Re: *Sanctuary of Peace PUDSP-19-002 – Review 2*
MVE Project No. 61087

M.V.E., Inc. has prepared the following response to your comment memo dated December 3, 2019.

15/15

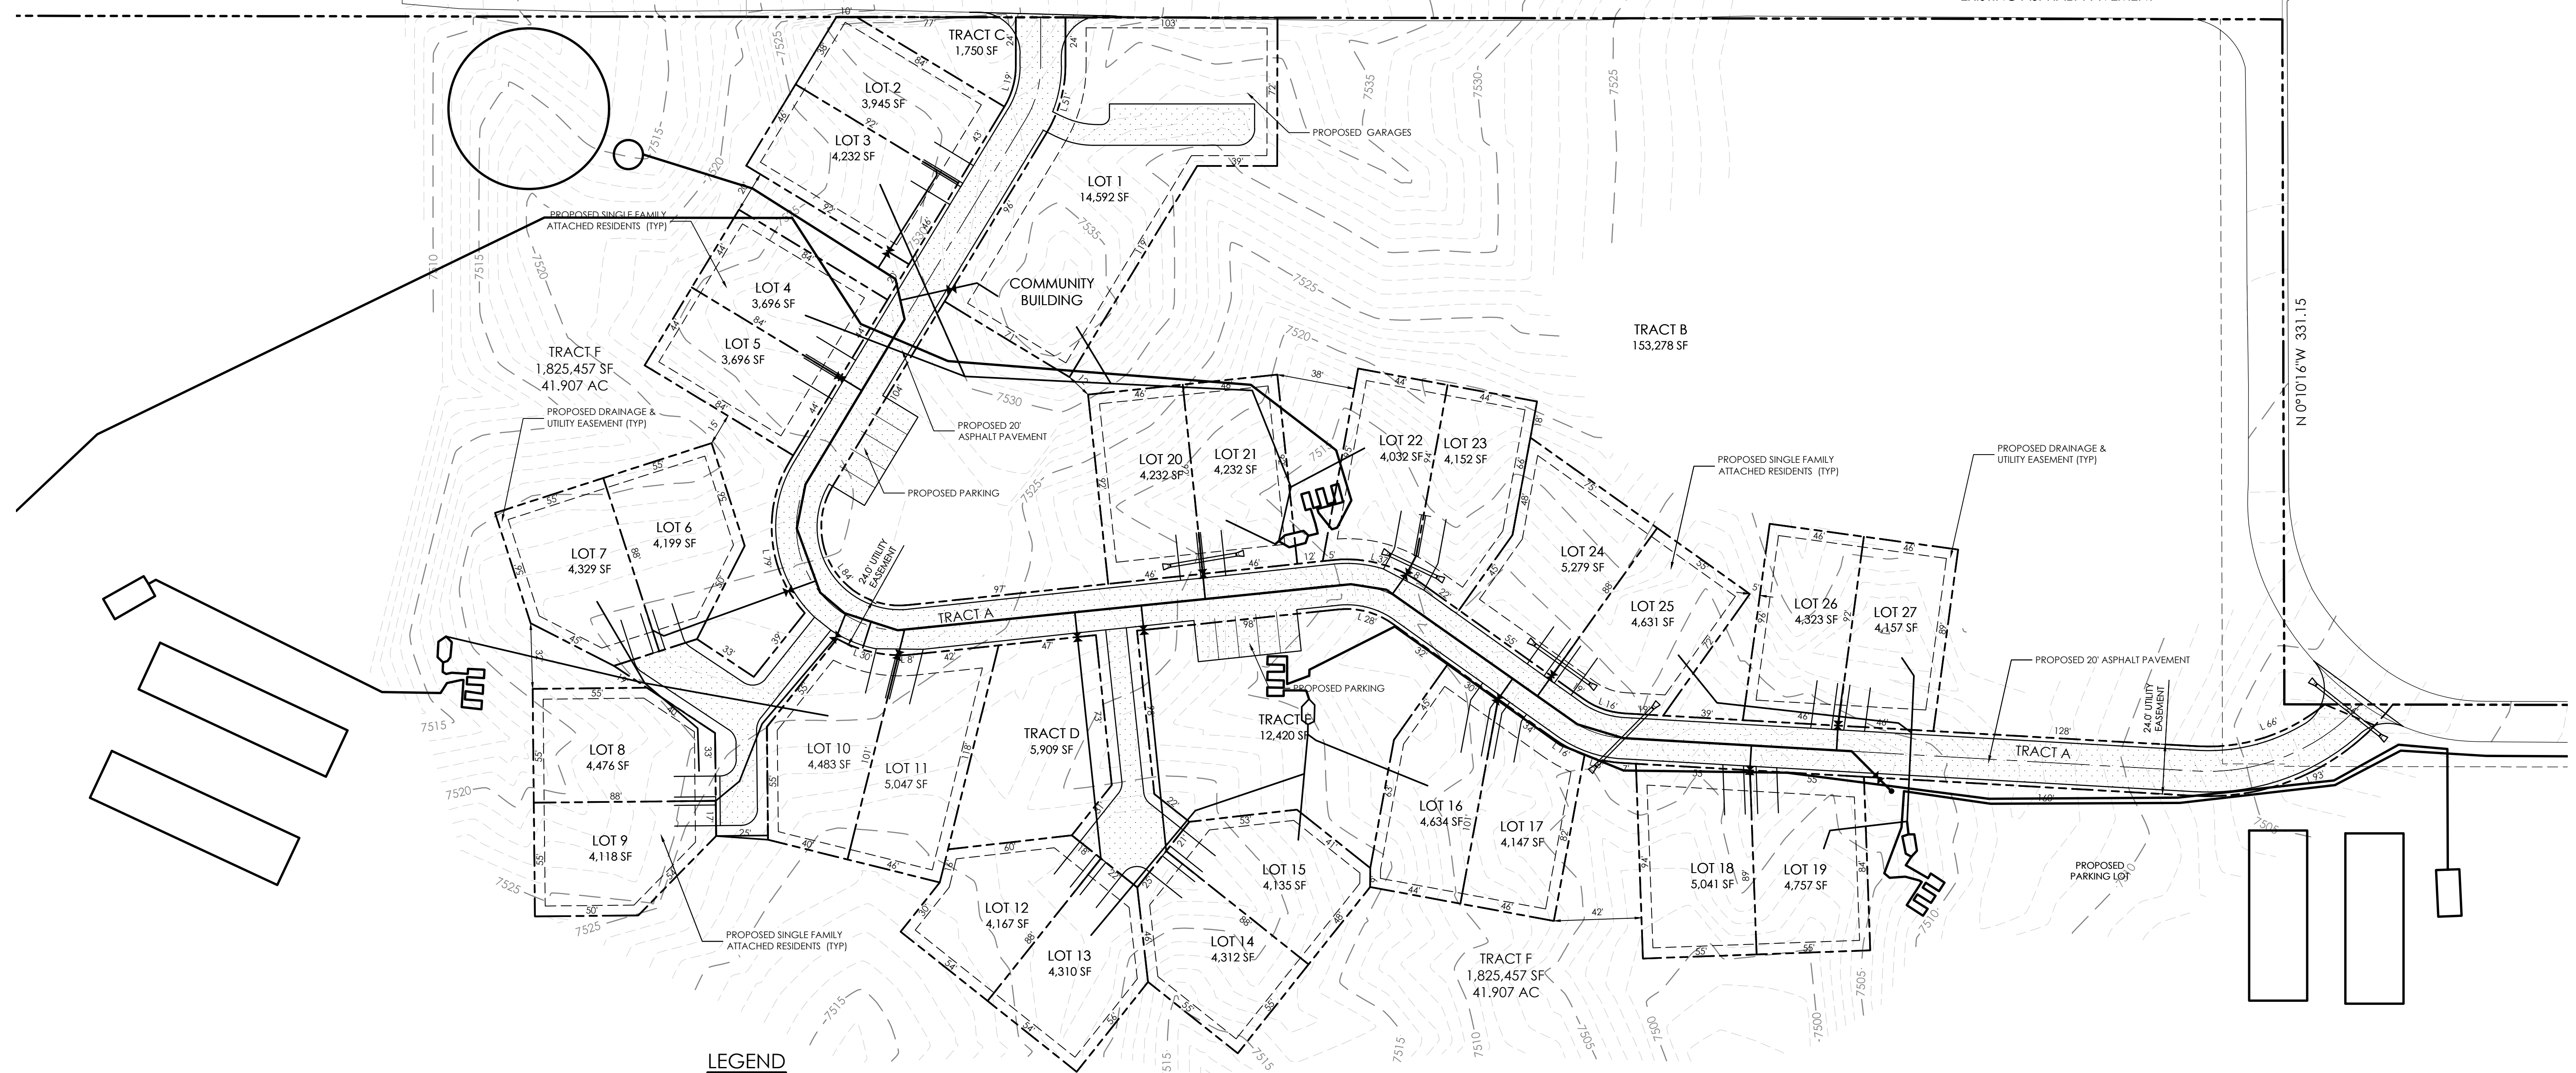
• Note: The 285 Engineering, 18June2018, OWTS design shows the proposed well zone of influence circle with a radius of 50', but must be 100' minimum, and 8' of additional distance for each 100 gallons of wastewater flow over 1,000 gallons; therefore, the radius for the proposed well must be 140' from the zone of influence from the closest soil treatment area (appears to be soil treatment area 3). **200 ft zone of influence around each soil treatment area is shown on the plans. The well is outside the zone of influence. Please see attached noted plan page.**
